A.P. - 24 Astorville St.

May 13, 1965

Consent

Permit to demolish a 2-story open porch 15'x7' and to construct a new 2-story open porch 8'x7'. As being issued subject to restrictions as follows:

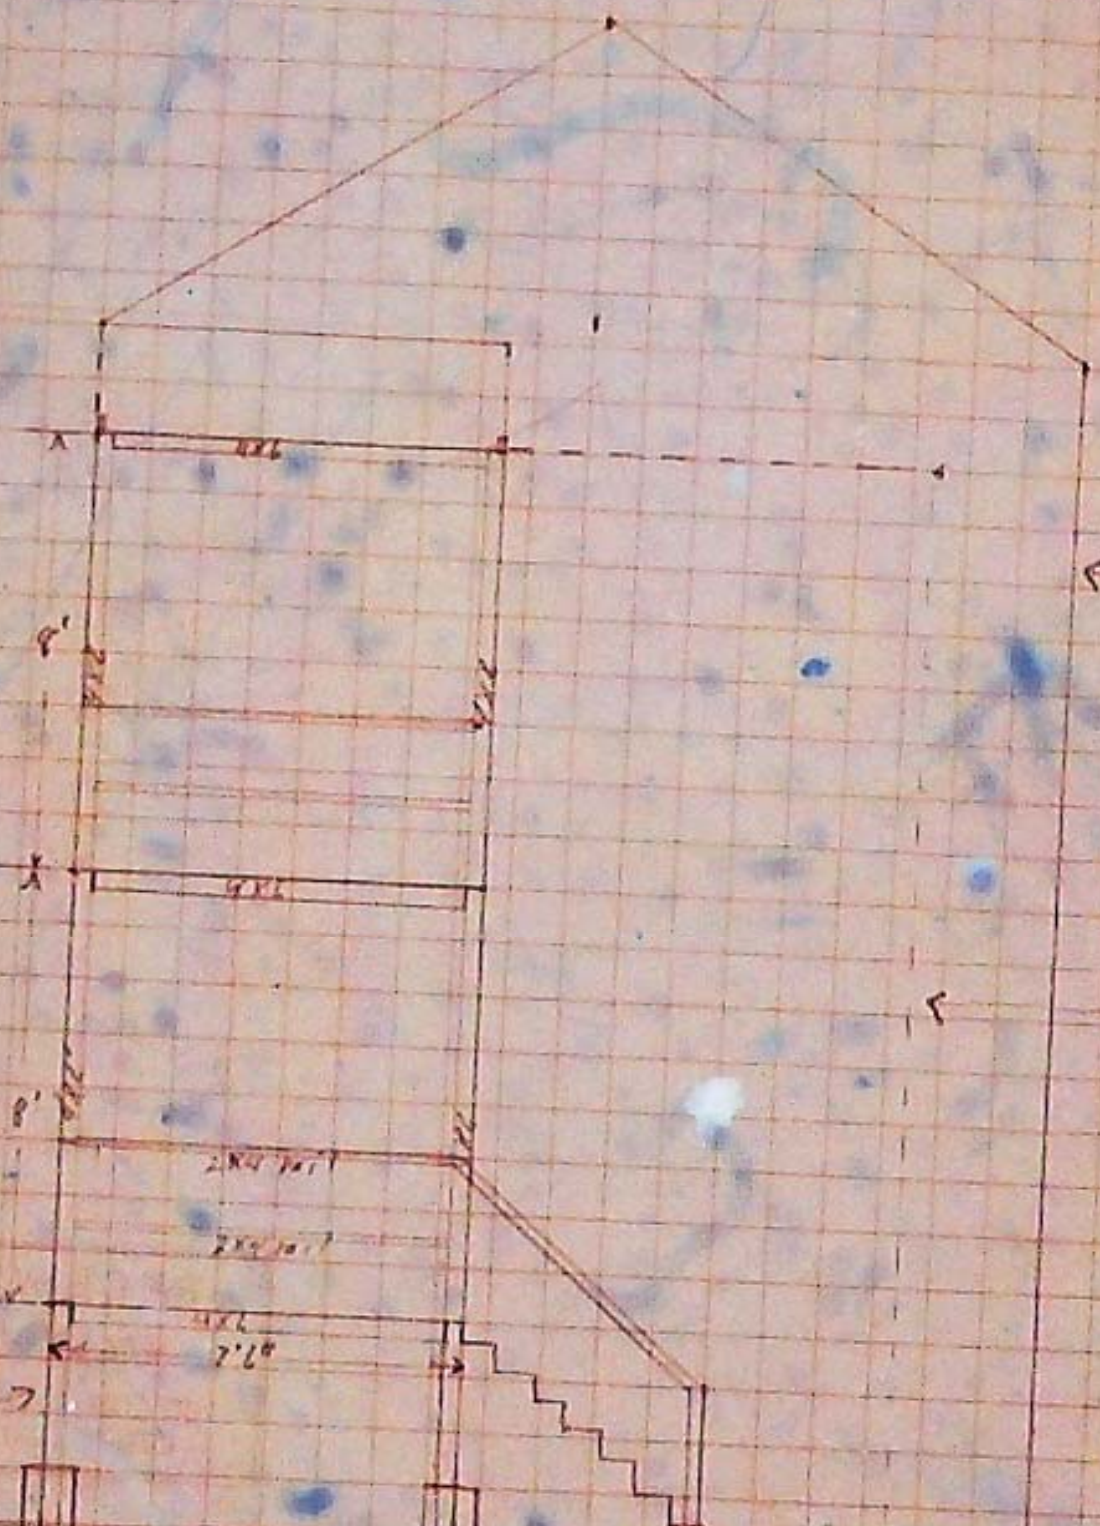
1. Corner posts of open structures shall bear directly upon the sill and shall be continuous from sill to plate with lap splices no less than 18" in length permitted.
2. If angles are to be used to support the sills at the corner posts we will need to know the size of angles and size and number of lag bolts to be used in each case. These connections will need to be approved before the form inspection for the concrete pier forms is called for.
